From: Sarah Burrow <Sarah.Burrow@arun.gov.uk>
Sent: 29 October 2019 16:48
To: Chris Slade [REDACTED]
Cc: Jacob Napthine [REDACTED]
Amber Willard <Amber.Willard@arun.gov.uk>
Subject: RE: Planning Consultation on Y/93/19/DOC

APPLICATION NO: Y/93/19/DOC

Site Address: Normandie Church Lane Yapton BN18 0EH

Description of Works: Approval of details reserved by condition imposed under ref Y/47/19/HH relating to Condition No 4 - proposed surface water drainage.

TRENCH SOAKAWAY USING POLYSTORM LITE GEOMODULAR UNITS
LANDSCAPED AREAS ONLY

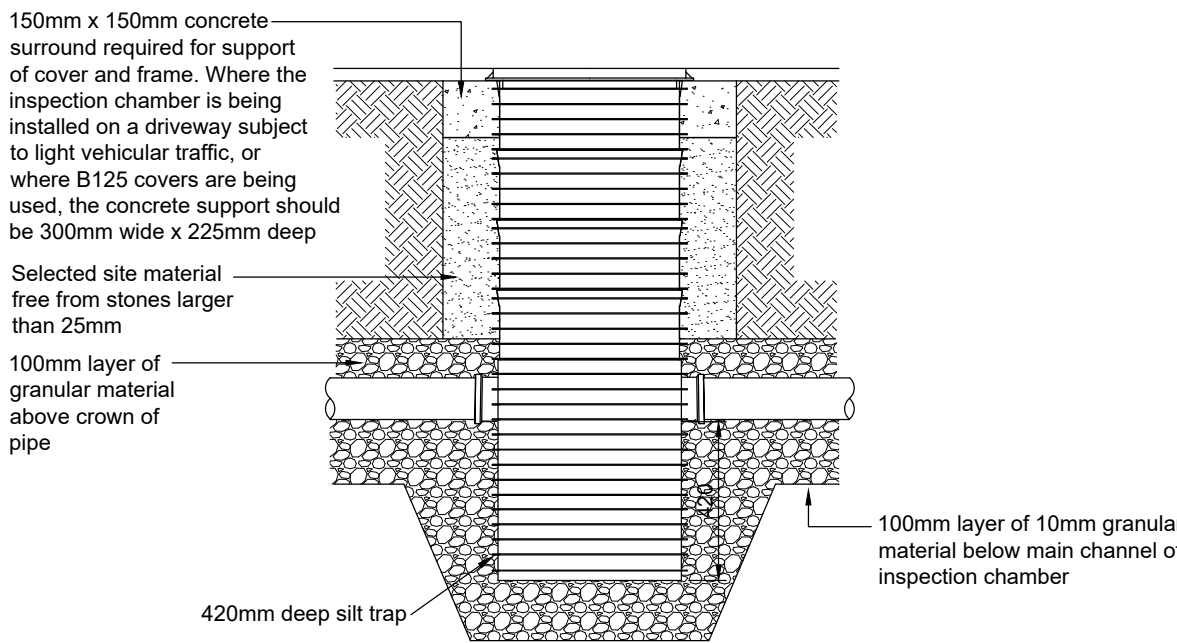
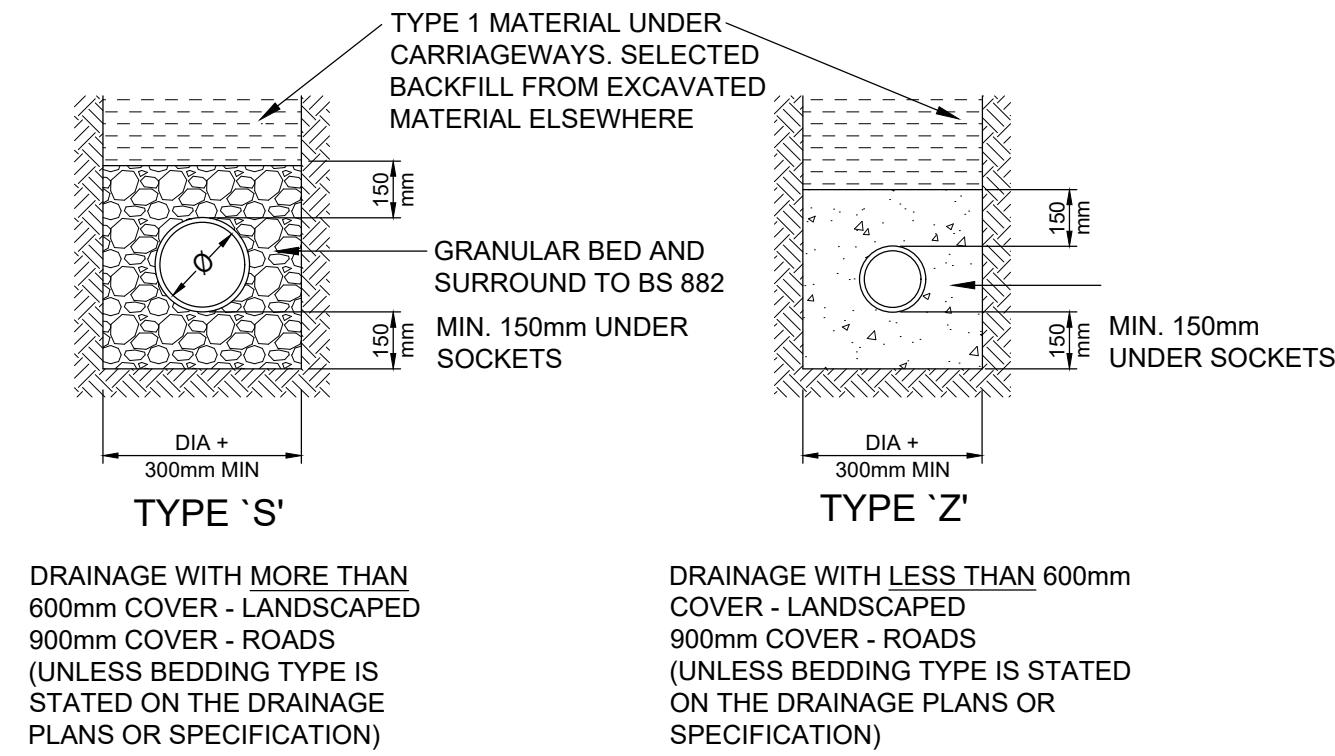
6. The pipe must not go into the base of the soakaway, it should be at the top of the crates. Please adjust drawing and levels to reflect this. – Adjusted and attached.

7. Please label cover levels at rainwater pipes and/or the falls to the silt trap. – Adjusted and attached.
8. Please make it clear on the drawing that S1 is a silt trap and clarify whether it is a 450 or 460 diameter. (Plan drawing and detail are labelled differently.) – Adjusted and attached.

Appendix A – Soakaway Test Location Plan

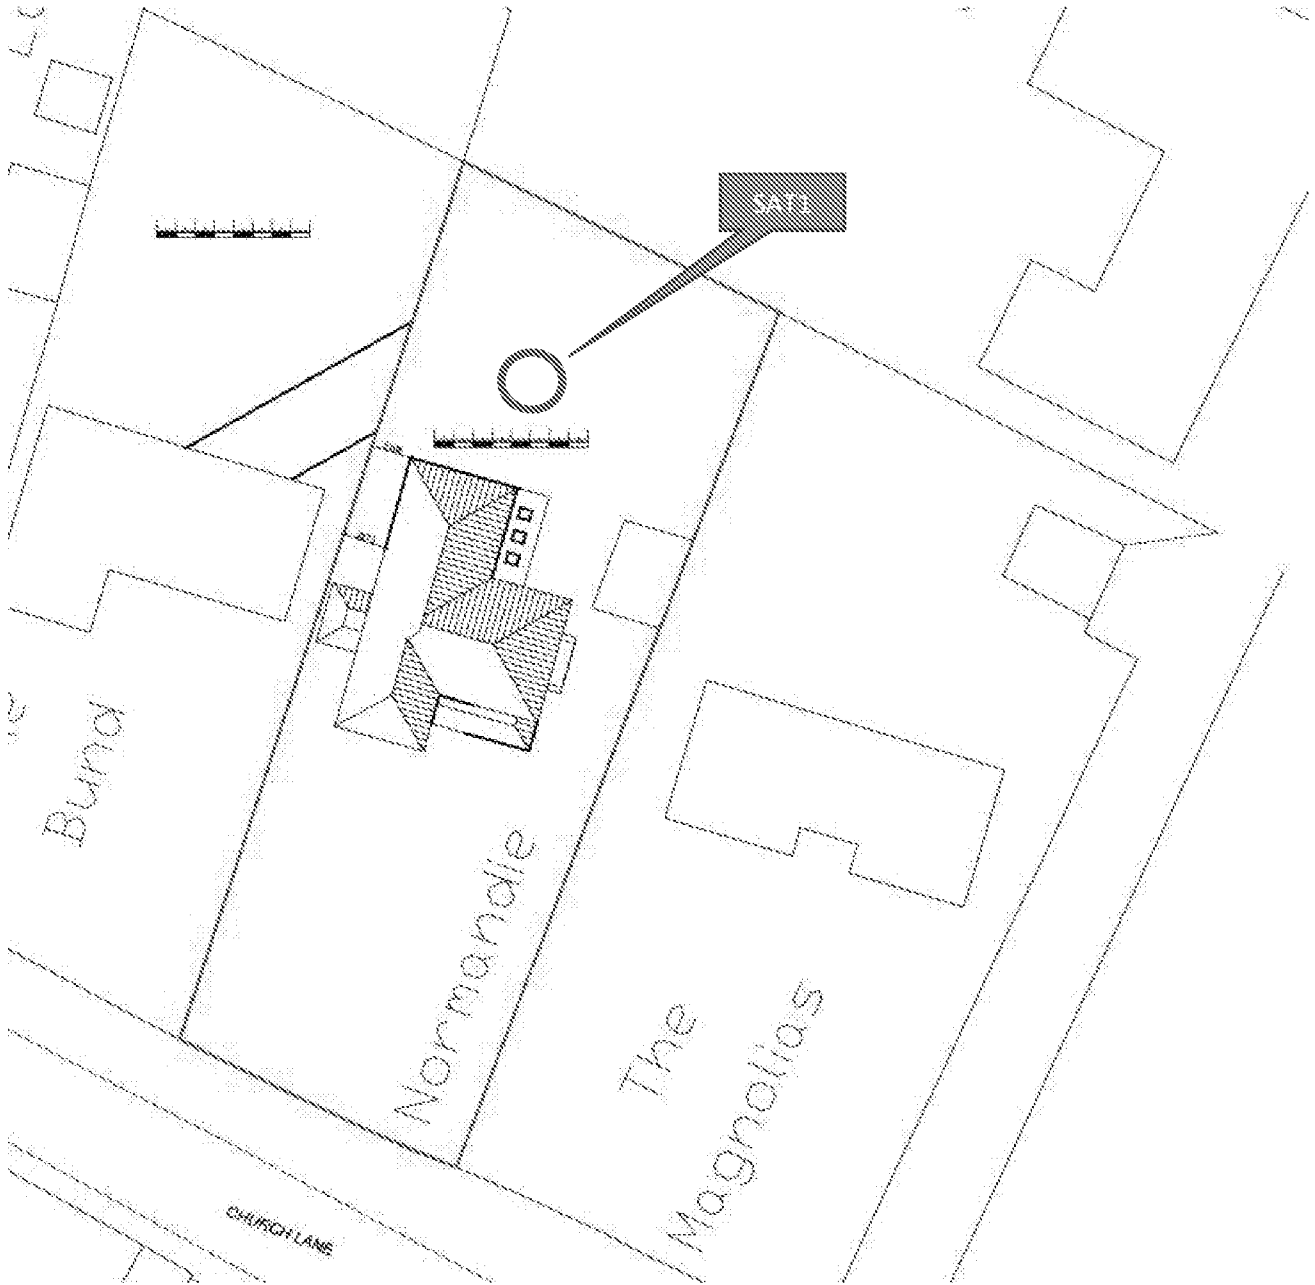
3. For future reference, the trial pit dug for the infiltration testing is too small and not in accordance with BRE 365. Guidance states that the pit should be 0.3-1m by 1-3m in area. – Noted although on this occasion we were restricted on space and hand to hand dig to reduce water requirements. There was no access for an excavator or water bowser.
